Online Comment

Application	H16-0801-25
Location	The Sessions House Sheep Market Spalding PE11 1BB
Proposal	Installation of two exterior illuminated signs on the front railings - Retrospective

Name	Spalding & District Civic Society
Address	Spalding

Drawing Title: Front Elevation
Drawing Number: SH-SIGN-002

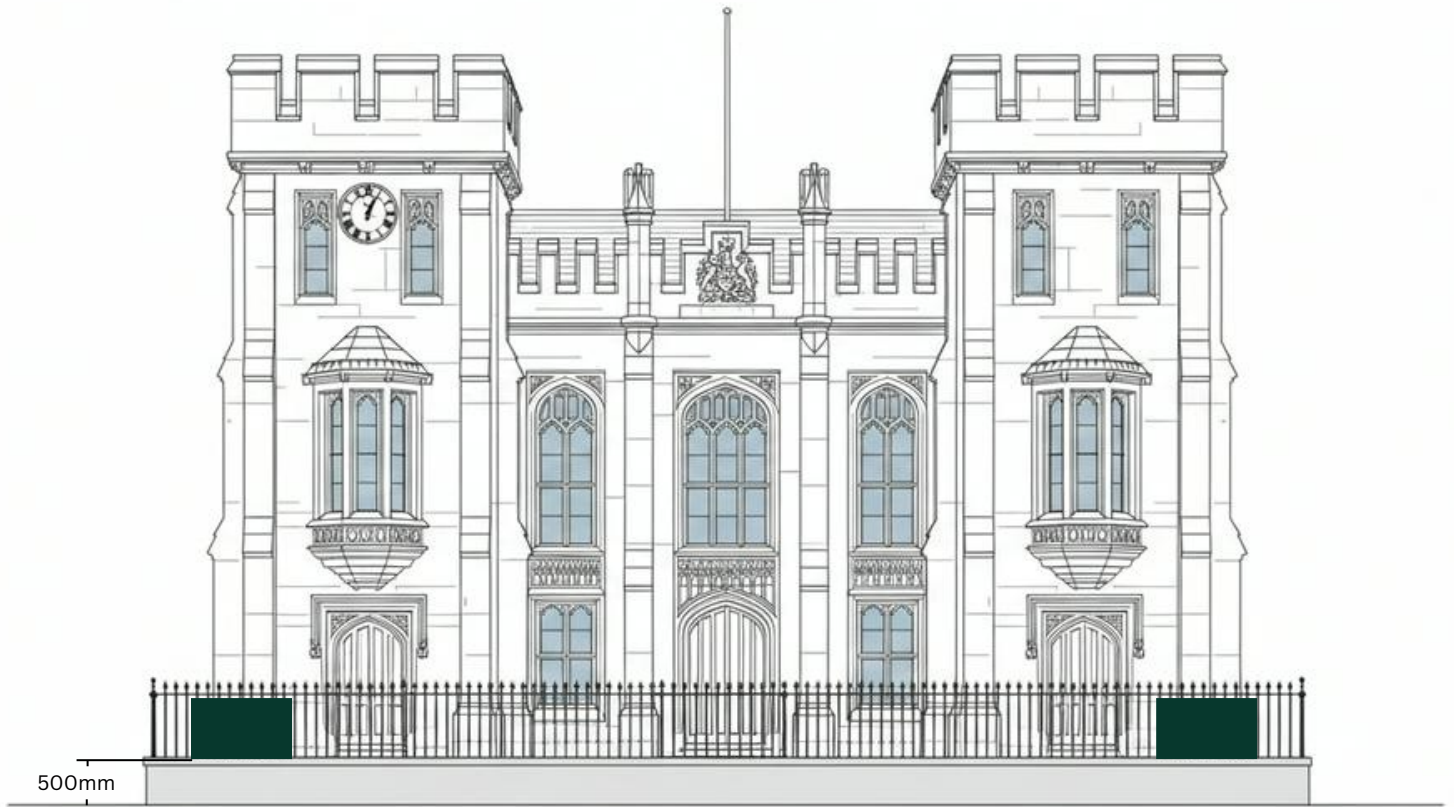
The Sessions House is a grade II listed building within the Spalding conservation area. As such the listed building consent application needs to be considered taking into account paras 202-214 of the National Planning Policy Framework, in particular para 210 and 212. Whilst it is noted that the applicant, states that the signage is fixed to the railings in a non-invasive way, they do detract from the visual amenity of the site as a whole.

Despite the assertion of the applicant, the use of the white board does not represent a harmonious presentation. Instead, it represents an intrusion, for which the applicant has not offered any justification. Paragraph 215 of the NPPF requires the planning authority to consider whether the proposal provides a public benefit including whether it secures an optimum viable use of the building. In this case, we contend that the proposal does not make the usage of the building any more viable.

The Control of Advertisement Regulations 2007 cover the conditions for which consent for advertisements should be given. Illuminated advertisements in conservation areas are specifically prohibited with the Classes included within Schedule 3, Part 1. Furthermore, the dimension of each board at 2.088 sq metres exceeds the maximum of 1.55 sq metres set out within class 5 of the regulations.
